Recommendation Report for Planning Permission for Works or Extension to a Dwelling

REF NO: A/147/18/HH

LOCATION: 79 West Drive
Angmering
BN16 4JE

PROPOSAL: Proposed single storey rear extension

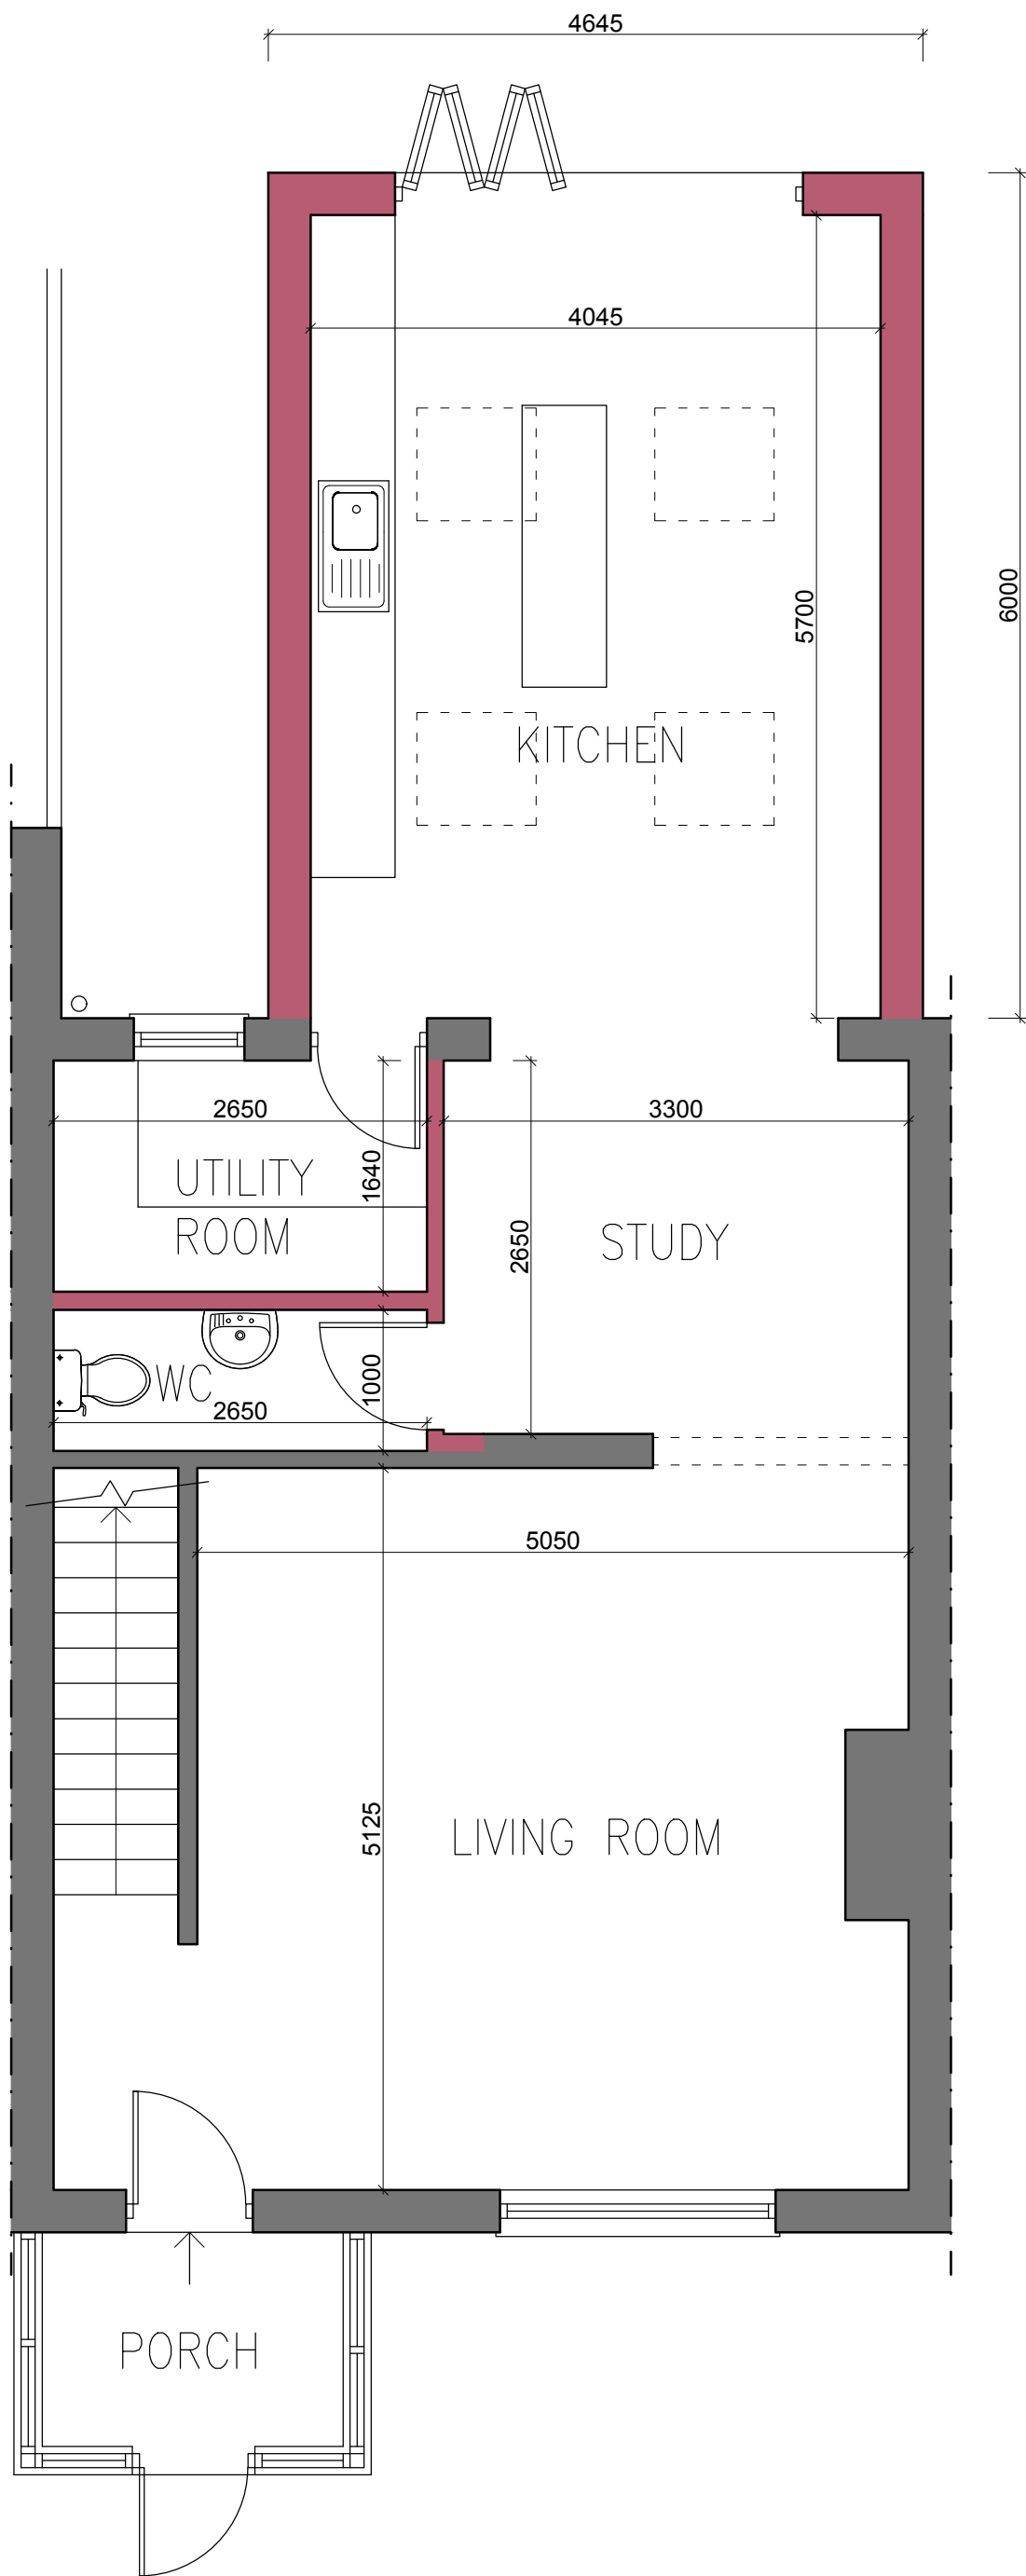
- Additional foundations may be required and then will they be inspected by a surveyor?
- Can blinds be fitted to the skylights to reduce light nuisance?
- Will the shrubs on my (the objectors) side of the fence be retained?
- How will access be gained to the gutters and eaves for maintenance?

Only planning matter can be addressed under the planning permission, therefore, matters relating to internal works, foundations and maintenance access are not considered under this application. With regard to the shrubs being retained, the planning permission does not give right to remove planting at other properties.

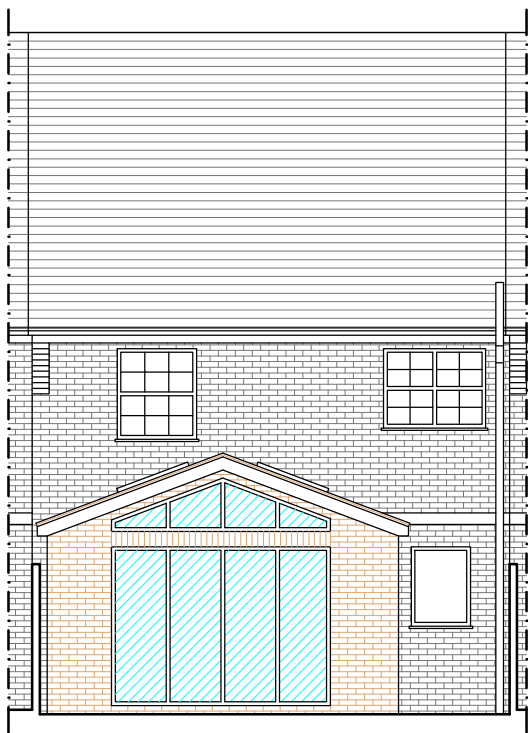
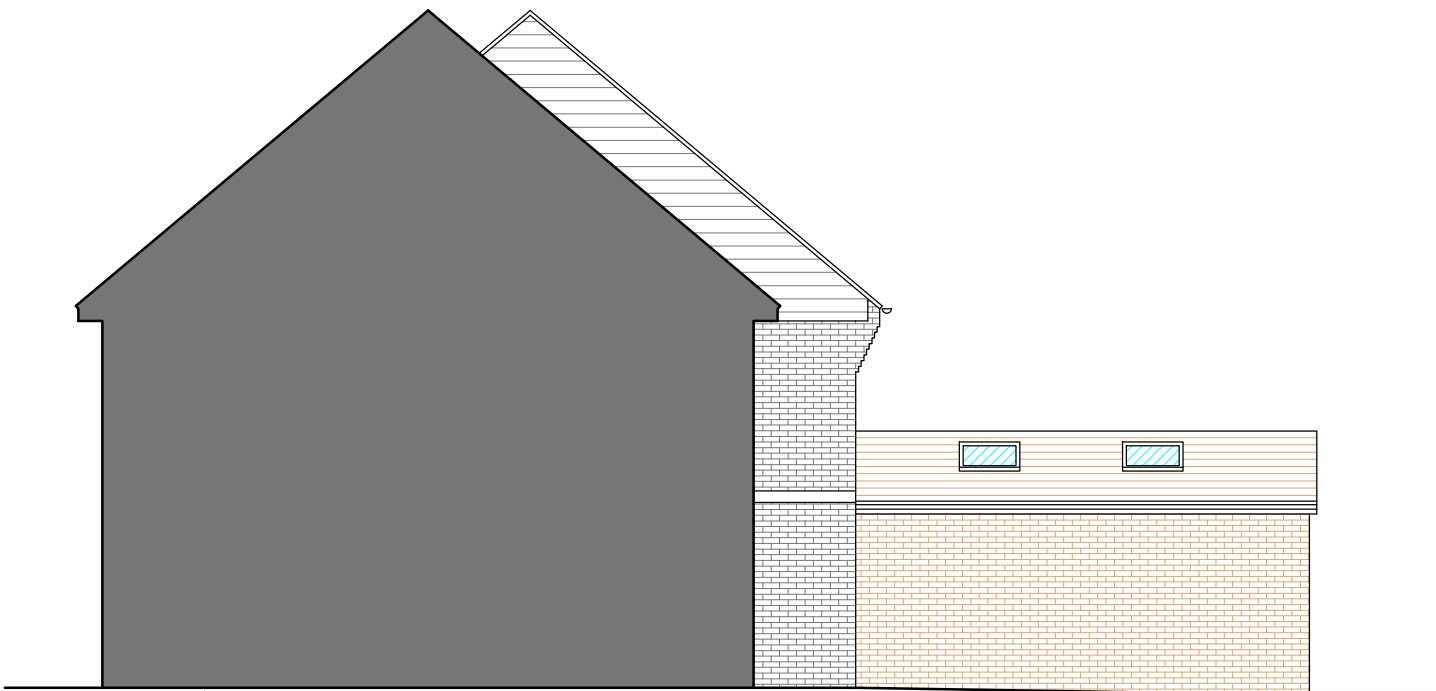
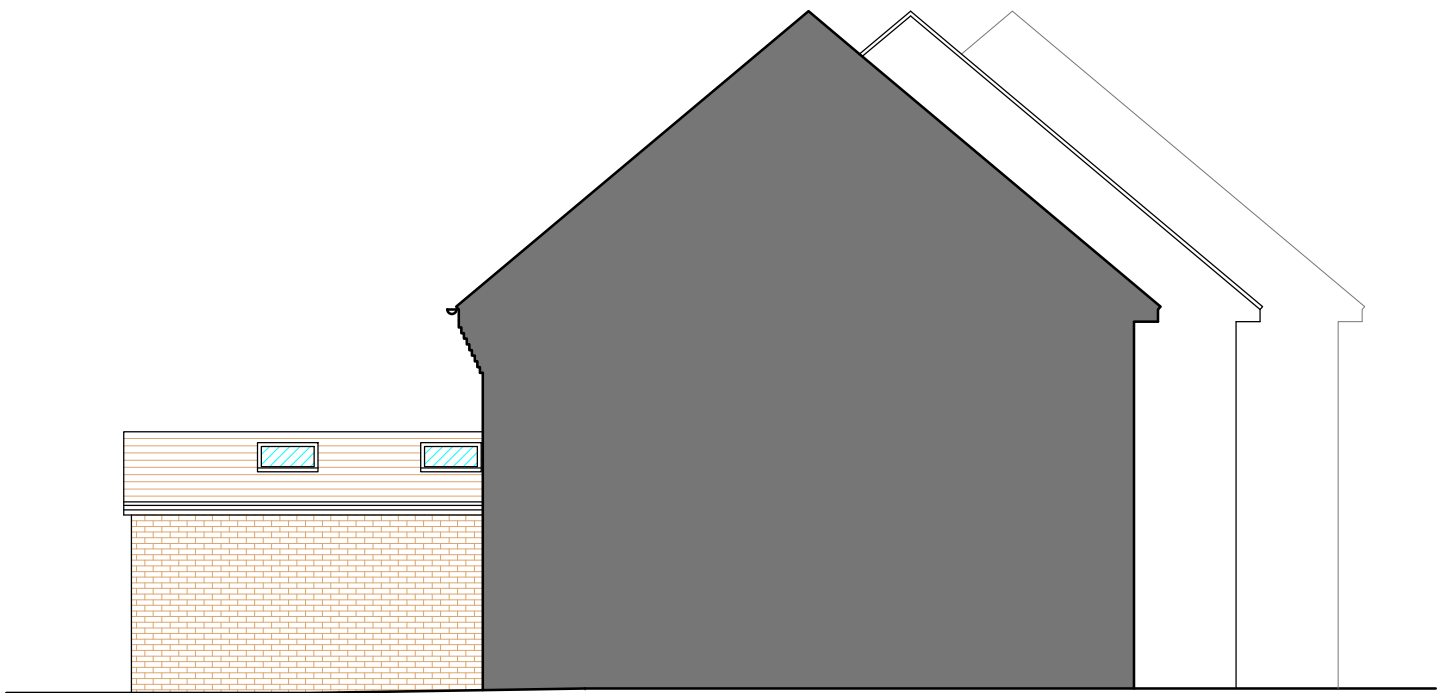
The maximum height of the proposed development is 3.5m from ground level, which is 5.5m lower than the ridge height of the host dwelling. Therefore, the proposed development is considered to appear subservient to, and not harm the character of, the host dwelling.

The proposed development is not considered to have any significantly harmful impact upon the residential amenities of neighbouring occupiers. Whilst the proposed development has a maximum height of 3.5m, this slopes down to 2.6m at the eaves, which is then 1.5m, and 0.1m from the Northern and Southern boundaries respectively. Whilst there is only a small gap between the development and the dwelling to the South, there is not considered to be any significant overbearing or overshadowing, as a result of both the low eaves height, and the boundary treatment. The proposed development is single storey, and therefore it does not provide any views that are not already available from the existing conservatory. Nor is it significantly more prominent on the boundary than the existing conservatory and the existing boundary treatment helps to lessen any additional impact in this respect.
